Final Report - Corrections Required **Application No. LUPL-25-0008**

Address : 0 14-15-65

Record Type : Land Use Plan

Document Filename : EPC Eng Comments_7.9.25

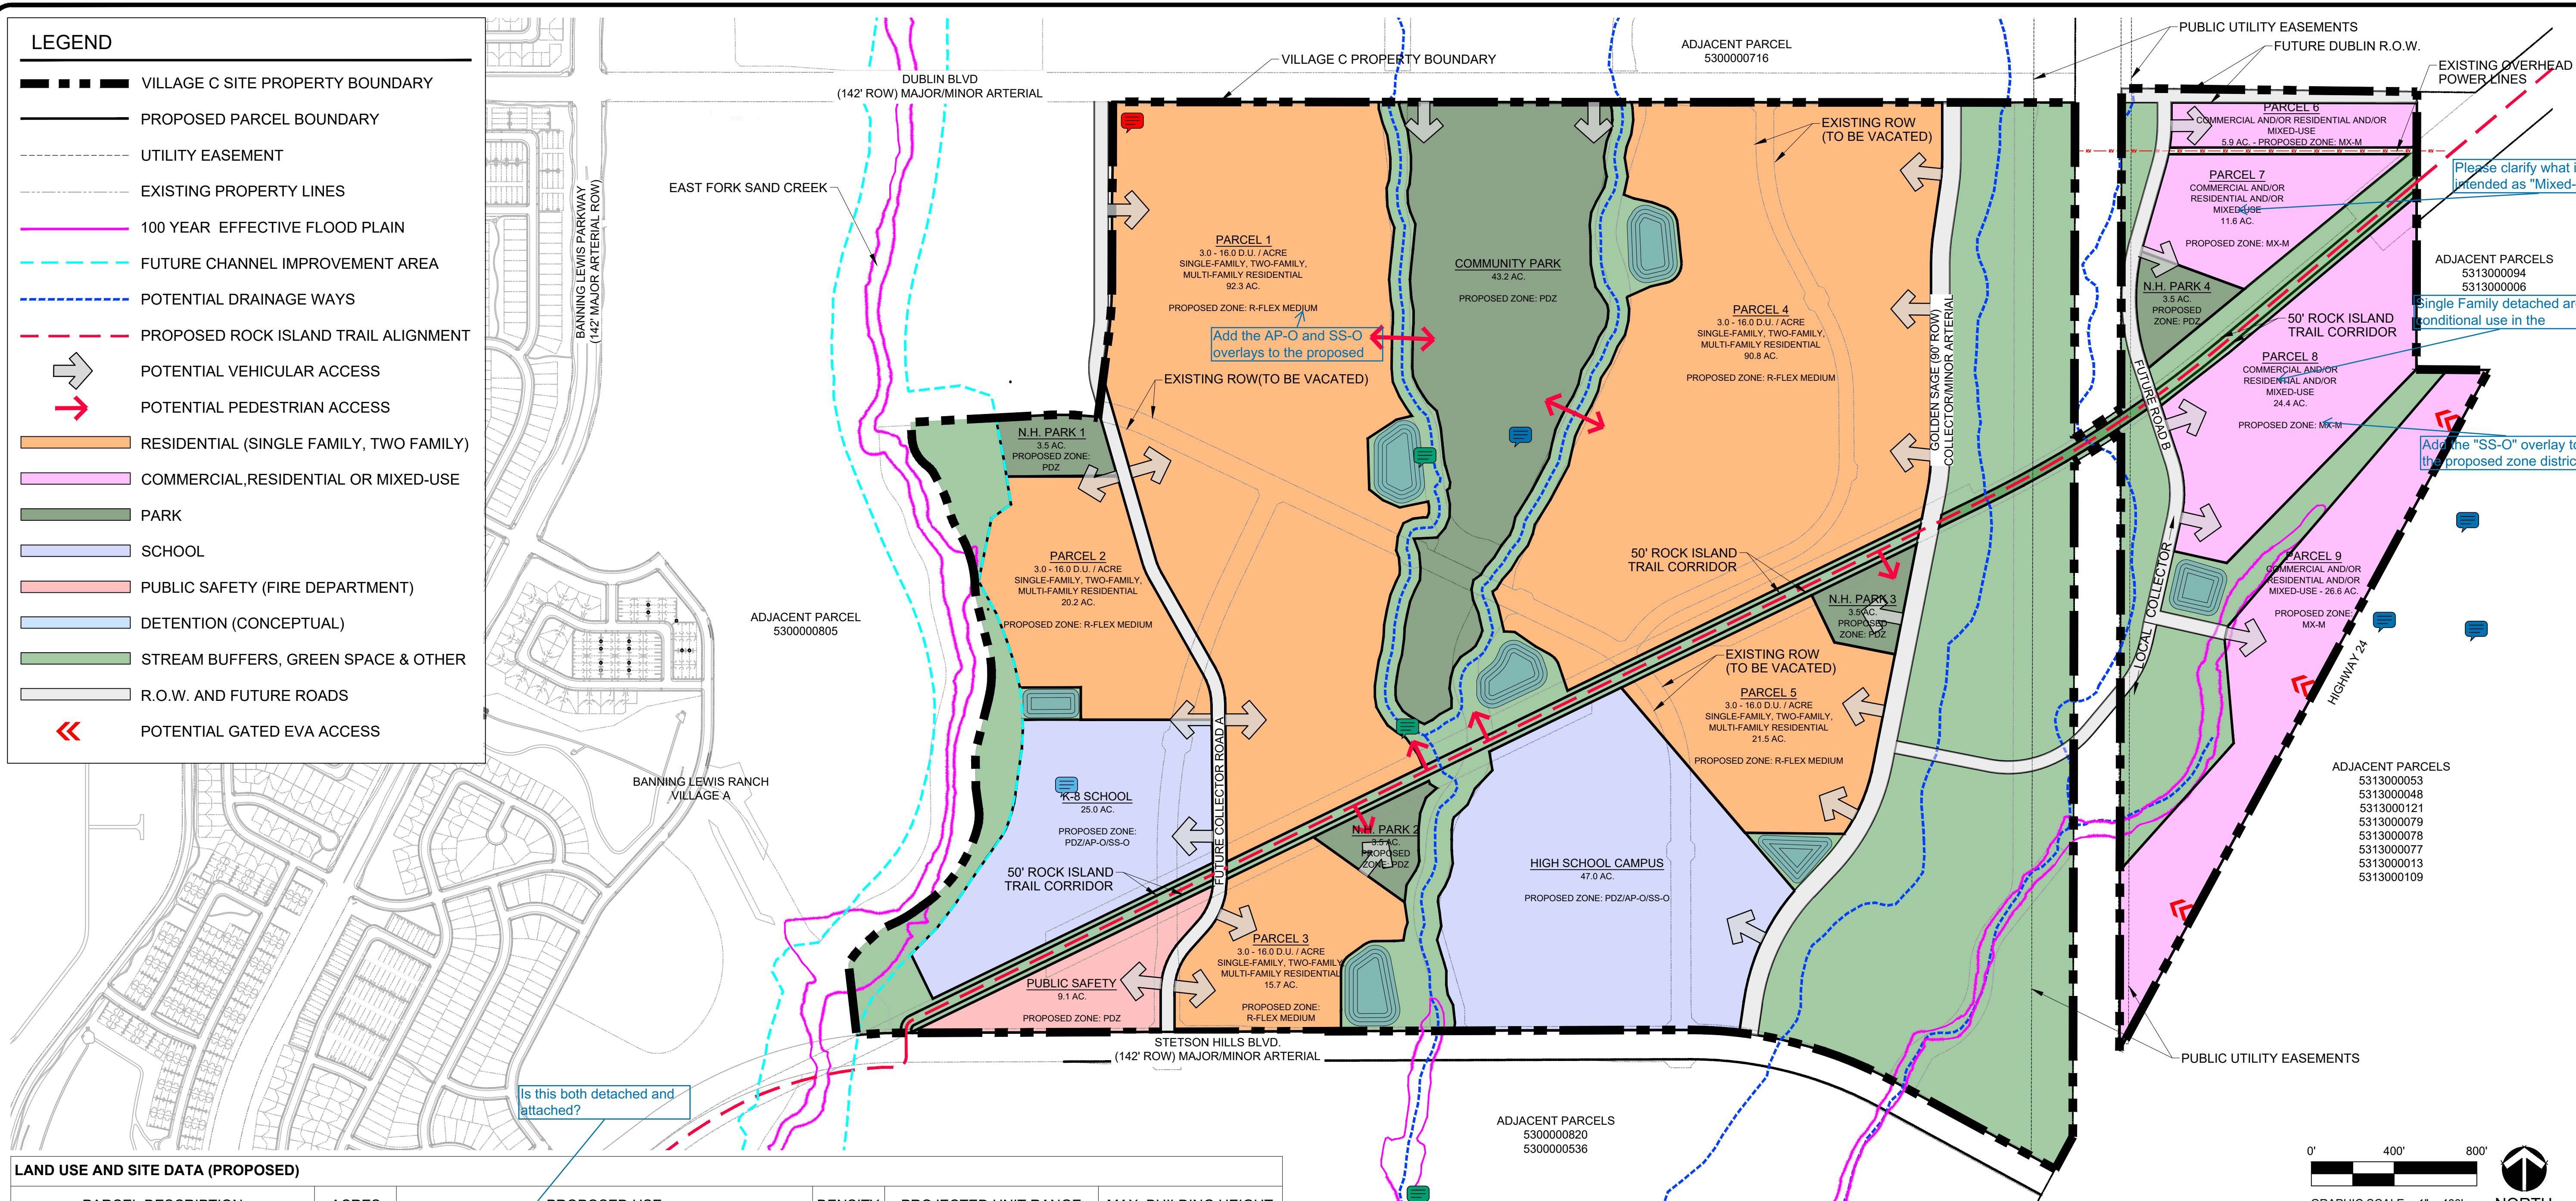
Why is ROW half of what is needed? (If Dublin is proposed to be split between incorporated and unincorporated areas, property acquisition from Falcon Highlands and EPC will be needed and County trail alignment (Rock Island and Falcon Hwy routes) in Tamlin Road ROW will need to be addressed.) (There was some coordination with Tim Roberts at the City in July 2022.)
